An  
Bord  
Pleanála

Lodgement Number : **LDG-067763-23**  
Case Number: **ABP-318268-23**  
Customer: **The Moore Street Preservation Trust**  
Lodgement Date: **23/10/2023 11:40:00**  
Validation Officer: **Dáire Littleton Caden**  
PA Name: **Dublin City Council North**  
PA Reg Ref: **5432/22**  
Case Type: **Normal Planning Appeal PDA2000**  
Lodgement Type: **Appeal**

Re. Appeal against the decision of Dublin City Council to grant planning permission for development at No. 61 O'Connell Street Upper (a Protected Structure), including the rear onto Henry Place, Dublin 1.  
DCC Reg. Ref. 5432/22

## GROUNDS OF APPEAL

Fig. 54
Illustrative drawings of No.61 Upper O'Connell Street.
Note: Drawings are not to scale. The drawings within this report are for illustrative purposes only. Please refer to detailed drawings submitted with the application for accurate dimensions and information.

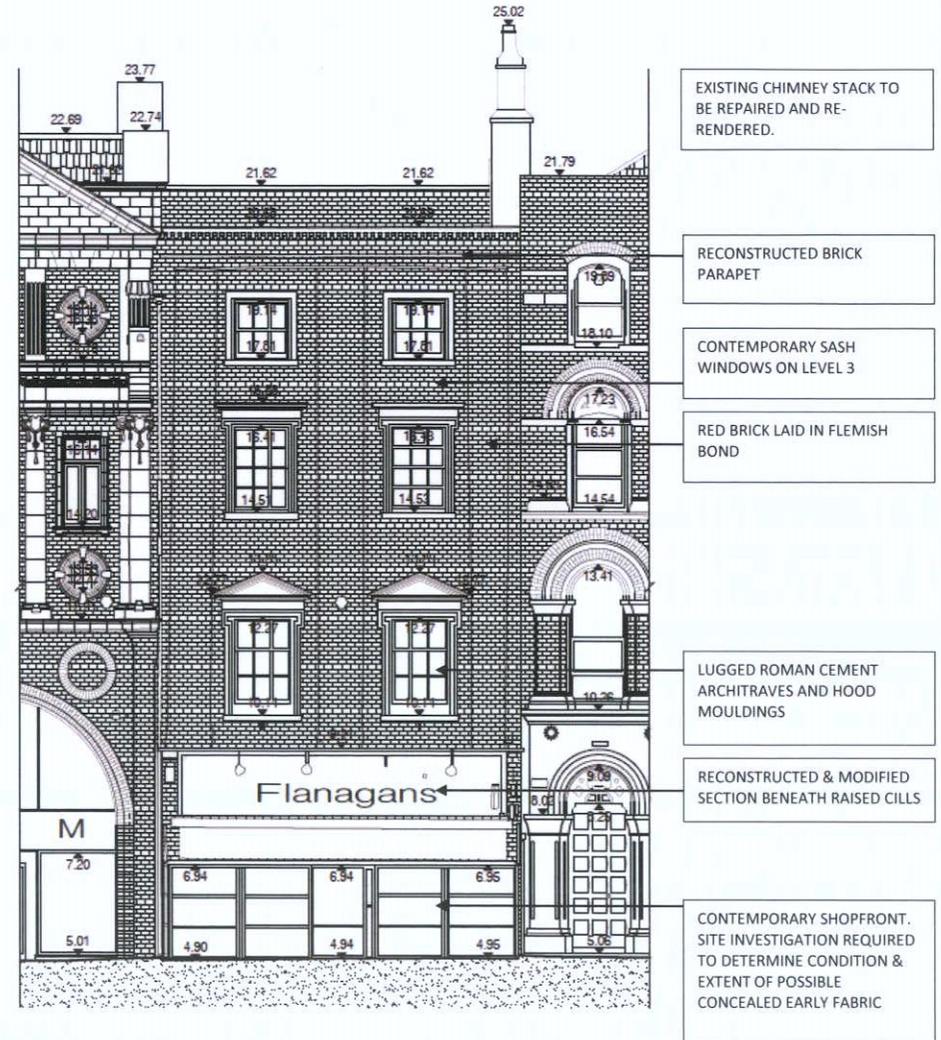
The Moore Street Preservation Trust in particular questions the creation of the new access to be constructed through the Protected Structure at No. 61 O'Connell Street Upper (see above in green). The developer has already proposed a new street and plaza elsewhere and the creation of an arched passageway through this Protected Structure is unnecessary. It will also be difficult to manage as there will be gateway access into the new passageway.

Dublin City Council's own Record of Protected Structures (RPS) is intended to protect the front façade in total. DCC has ignored its own RPS and permitted a new passageway to be punched through this Protected Structure. The MSPT asks ABP to refuse permission for this unnecessary development.

The MSPT asks ABP to encourage the council to adhere to its own policy in future applications by refusing permission for part demolition to create the unnecessary passageway proposed in this application.
